**RE: Thurgood Subdivision
Grading & Drainage Plan
Engineer's Stamp Date: 08/16/20
Hydrology File: F14D078**

Based upon the information provided in your submittal received 12/01/2020, the Grading and Drainage Plan **is not** approved for Grading Permit and for action by the DRB for Preliminary Plat. The following comments need to be addressed for approval of the above referenced project:

SITE, GRADING & DRAINAGE PLAN

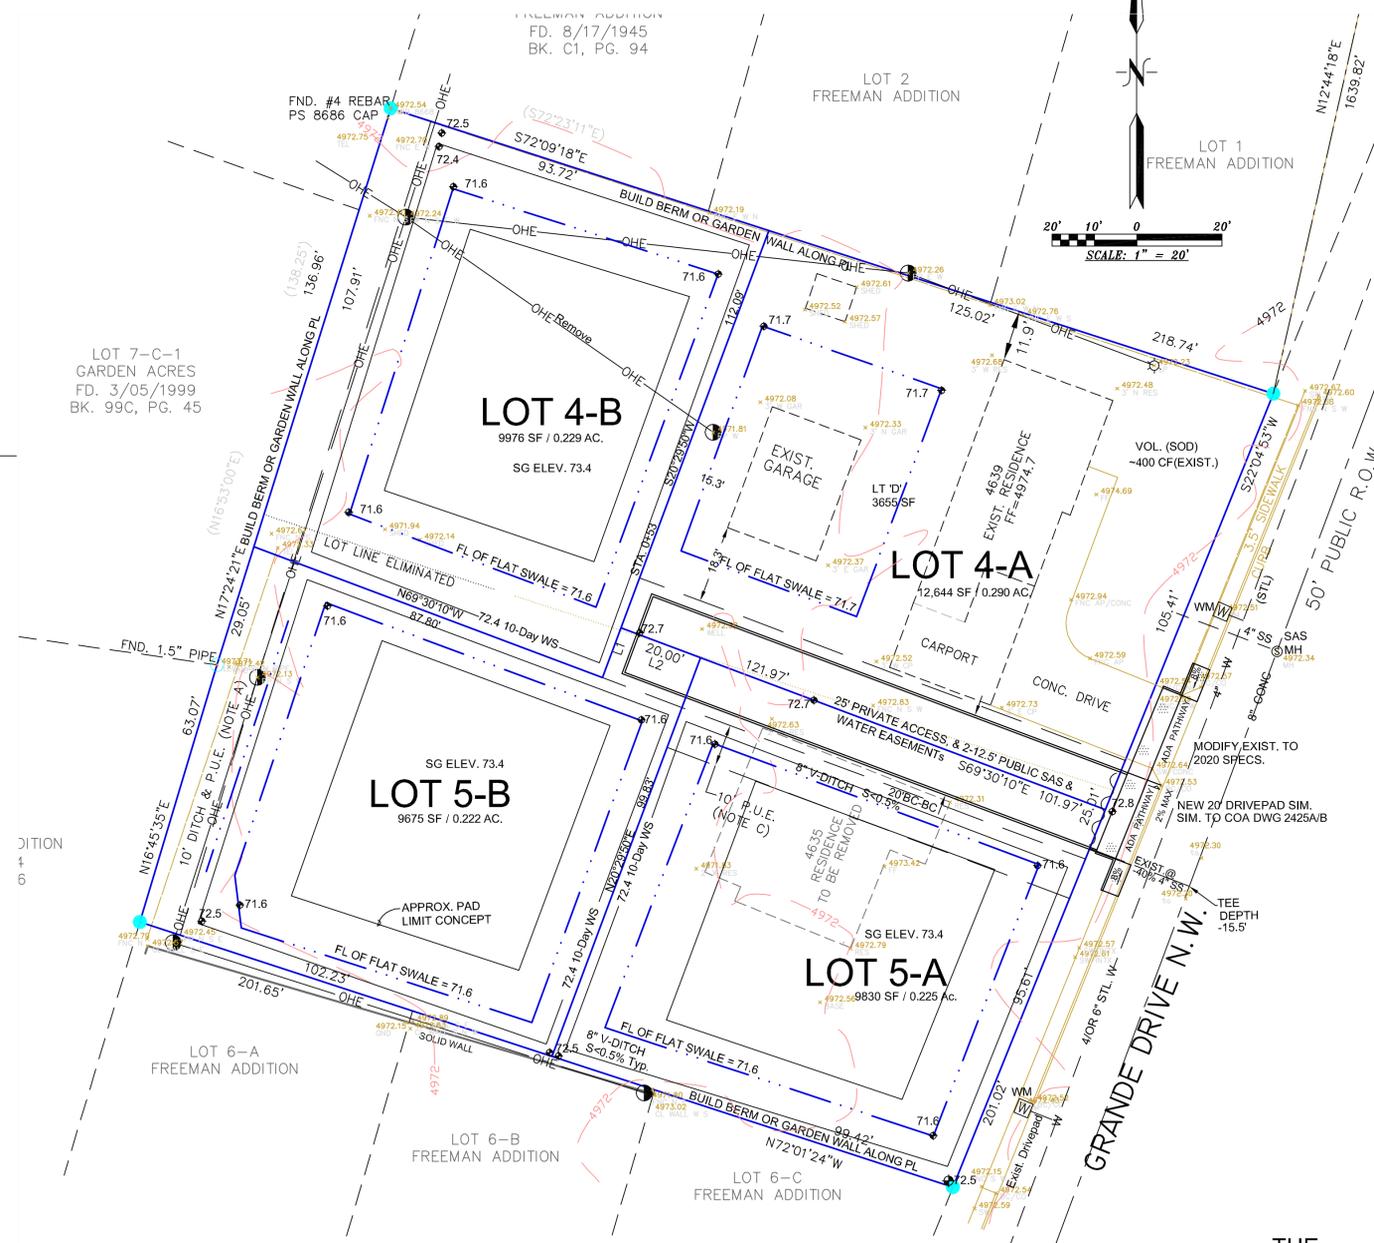
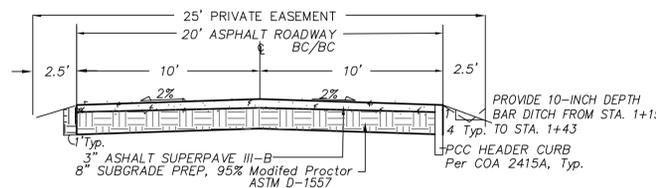
1. Please remove the reference to being compliance with the "Bernalillo County Flood Hazard Ordinance, 2009". Please replace this with "City of Albuquerque Development Process Manual (DPM) (signed 06/08/20) Chapter 6 - Drainage, Flood Control, and Erosion Control".

2. Since this site is in the Valley region, please follow Article 6-5 Valley Drainage Criteria of the DPM. Please refer to the update wording in the DPM. Also, please insure that the following conditions are be applied to the site some of these were not noted especially the location of each lots retention pond:
 - The maximum percent impervious of the lot and the contributing area may not be greater than 45%.
 - Pad elevation shall be a minimum of one (1) foot above the 100-year 10-day stormwater surface elevation.
 - The flow between the front yard and back yard cannot be obstructed. The stormwater must be allowed to equalize to the same level between the front yard and back yard.

- A permanent perimeter wall or barrier around the development is required to contain the 100-year 24-hour storm developed runoff.
- The high point of the street should be four inches above the 100 year 10-day stormwater surface elevation.
- Please show the required retention pond on each Lot along with the provided volume.

3. Please refer to the new DPM and please use the procedure for 40 acre and smaller basins as outlined in Development Process Manual (DPM) (signed 06/08/20) Article 6-2(a). All of your calculations need to be revised per these updated procedures.
